WEST SUSSEX COUNTY COUNCIL CONSULTATION

TO:	Arun District Council FAO: Michael Eastham
FROM:	Highways, WSCC: Tim Townsend
DATE:	20th August 2018
LOCATION:	Land at, Bridge Cottage & The Old Cottage, Lidsey Road, Bognor Regis, PO22 9PH
SUBJECT:	AL/20/18/OUT Outline application with all matters reserved for the demolition of 2 No. dwellings & associated outbuildings & the erection of up to 27 No. dwellings, of which 30% will be affordable, with associated open space & access. This application is a Departure from the Development Plan. <u>More information.</u>
DATE OF SITE VISIT:	
RECOMMENDATION:	☐ Advice ☒ Objection ☐ Modification ☐ No Objection ☒ More Information ☐ Refusal
S106 CONTRIBUTION TOTAL:	£ See below for details.

This is the second WSCC highways and transport response to the above outline planning application with all matters reserved for the demolition of 2 No. dwellings & associated outbuildings & the erection of up to 27 No. dwellings, of which 30% will be affordable, with associated open space & access. This report responds to additional information provided by the applicant and their agents – namely Technical Note produced by Reeves Transport Planning Consultants, refe

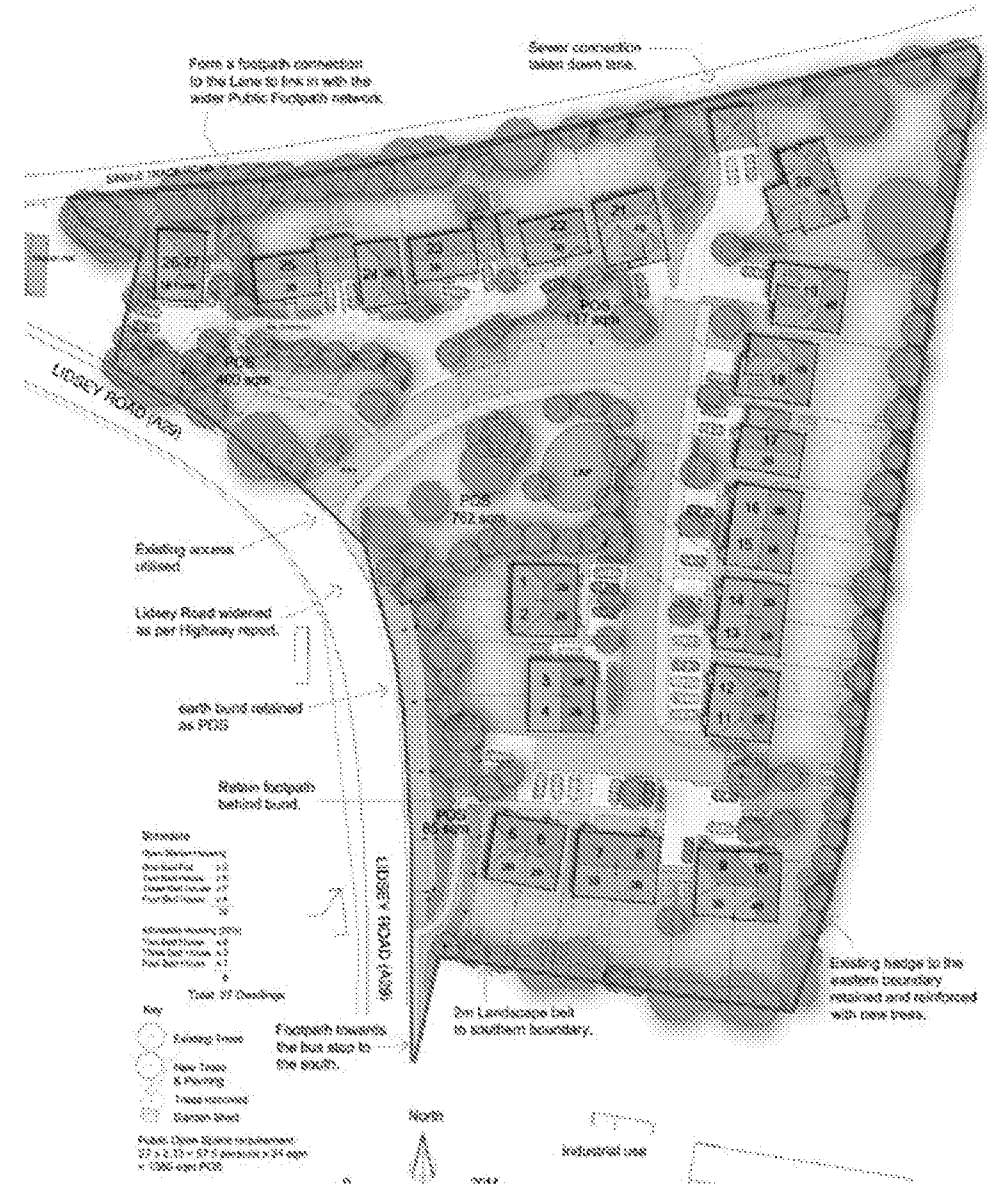
The internal layout is shown indicatively on drawing 1749-02G. As submitted, it is not clear whether it would be suitable for adoption under S38. This would be a matter to be looked-at at any Discharge Of Condition (DOC) or Reserved Matters (REM) staged. Also, it is not known what form of surface water drainage is proposed for the site which might itself dictate whether the layout can or can't be adopted.

With regard to access by refuse and fire appliances, the access drive shown to plots 22-27 might need widening as in places it looks slightly restrictive (particularly adjacent to plots 25-27). As such, this would have to be considered further at any RES/DOC stage.
